Project #: 1009463 Application #: 12DRB-70389
12DRB-70390
12DRB-70391
 Project Name: LANDS OF THE ATRISCO GRANT
 Agent: Tierra West LLC Phone #:

DEVELOPMENT REVIEW BOARD – SPEED MEMO

SITE PLAN FOR BUILDING PERMIT

**RE: DRB SUBMITTAL FOR SITE DEVELOPMENT PLAN FOR BUILDING PERMIT
TRACT A, OLD DOMINION FREIGHT LINE, INC.
10210 CENTRAL AVE SW
ZONE ATLAS PAGE L-08**

Sheet Name:
SITE PLAN FOR BUILDING PERMIT

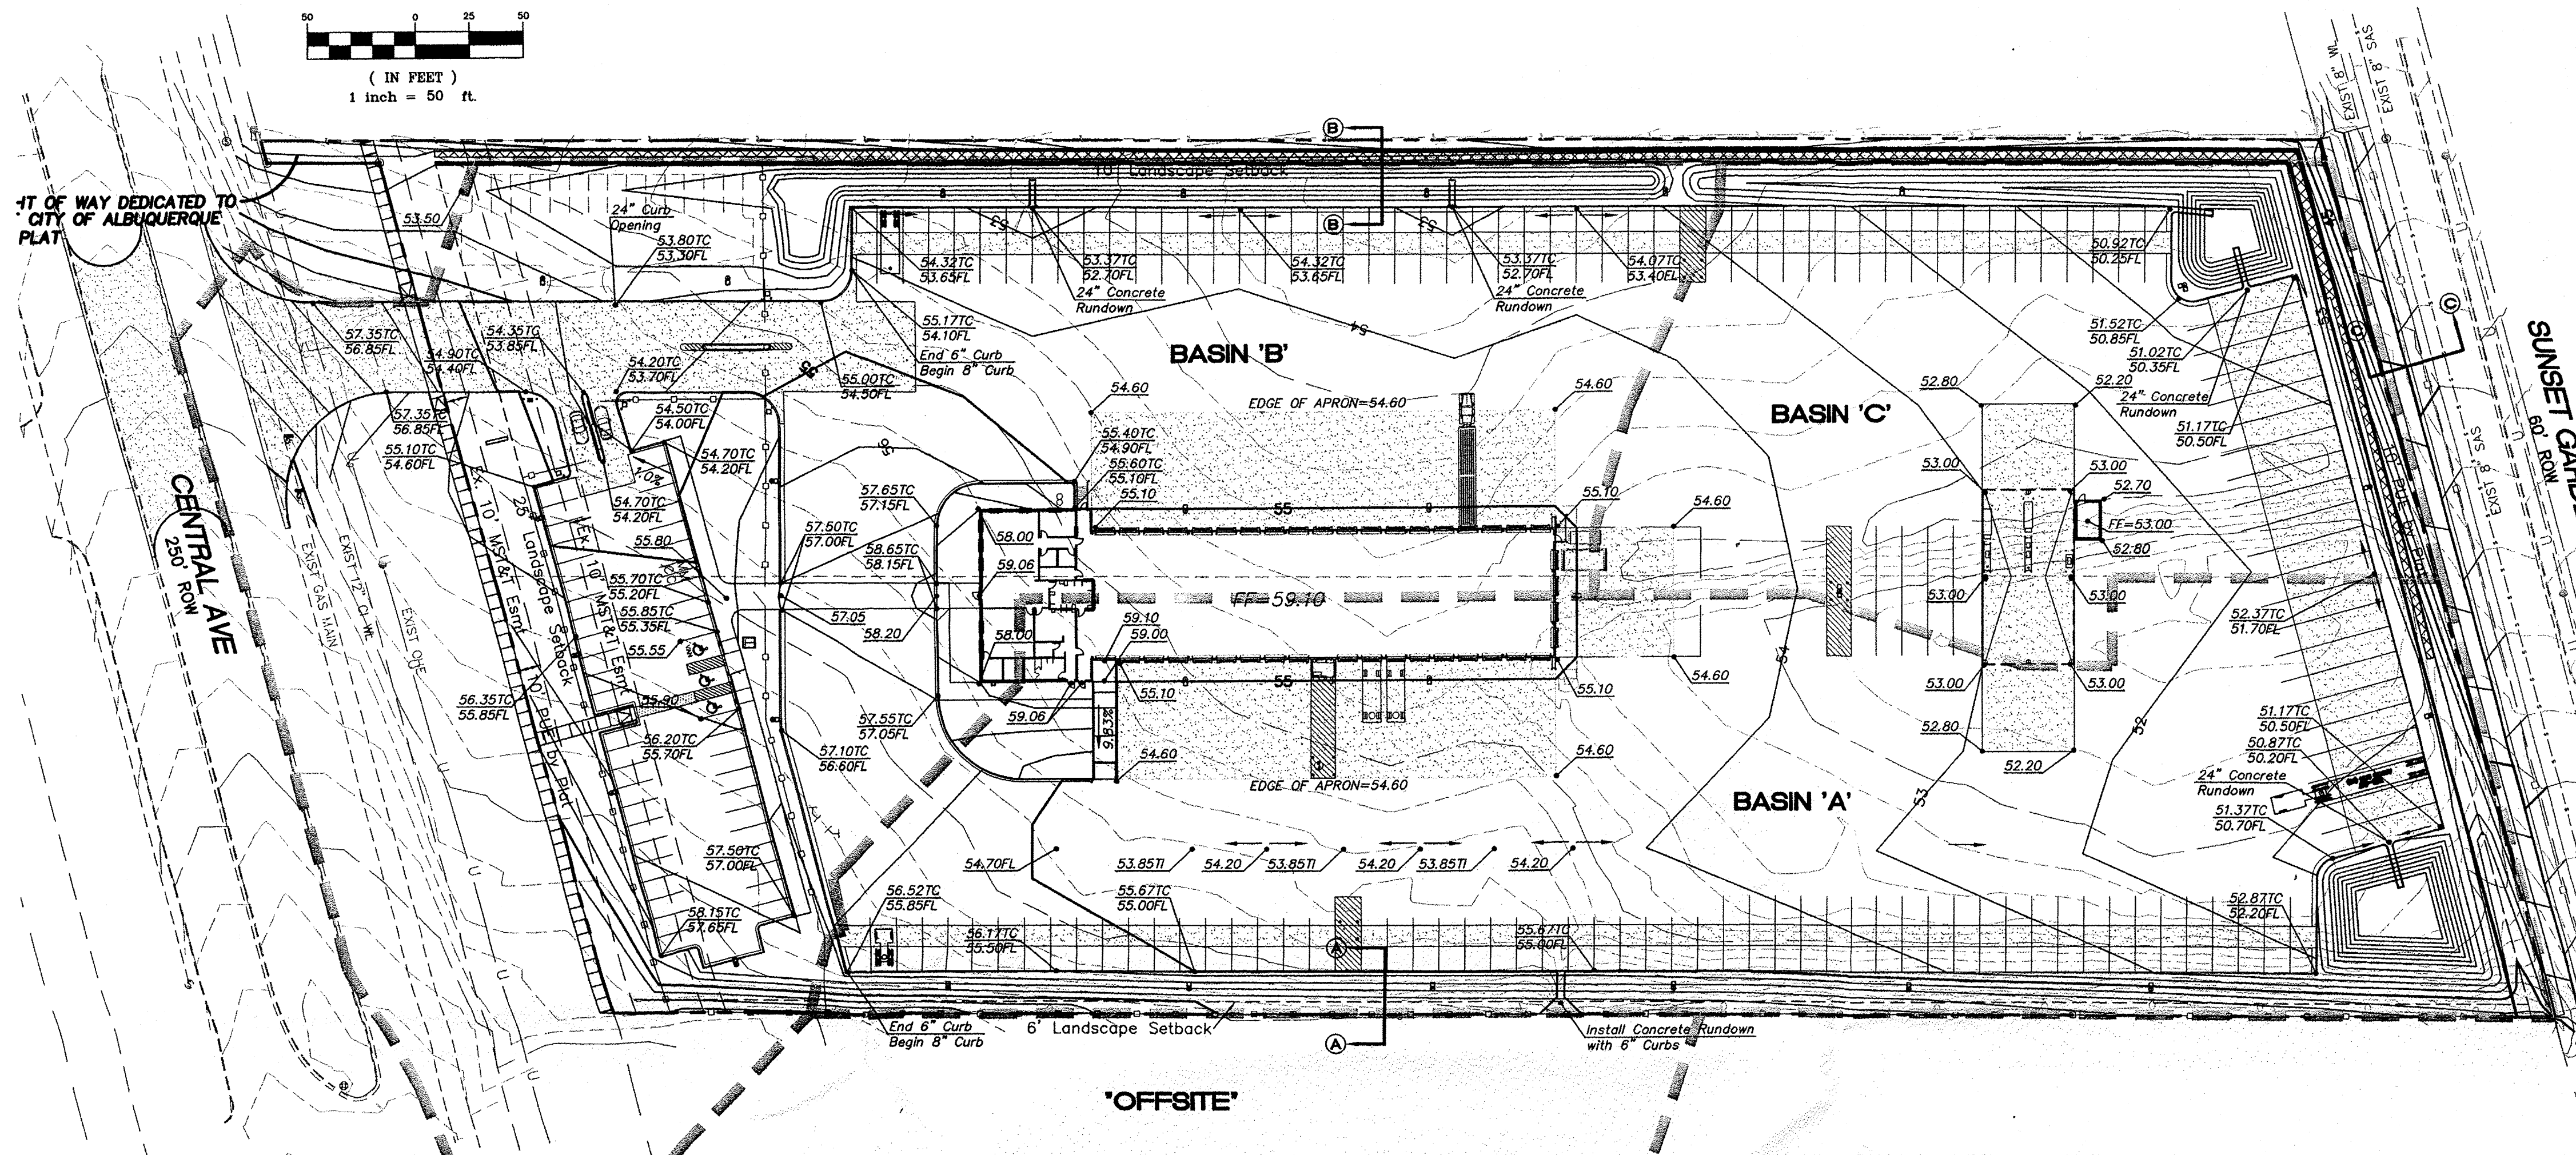
Show all ramps and provide details.

Define the width of all sidewalk.

Clarify the location of all gates. An appropriate turn around area must be provided.

Per the Department of Municipal Development, 500 feet of clear sight is required for approaching traffic on Central from 13 feet back of curb face (perpendicular to Central) from three feet to eight feet above gutter flowline is required. The landscaping plan must indicate this as well; walls, trees, and shrubbery over 3 feet tall (measured from gutter pan) will not be acceptable in this area.
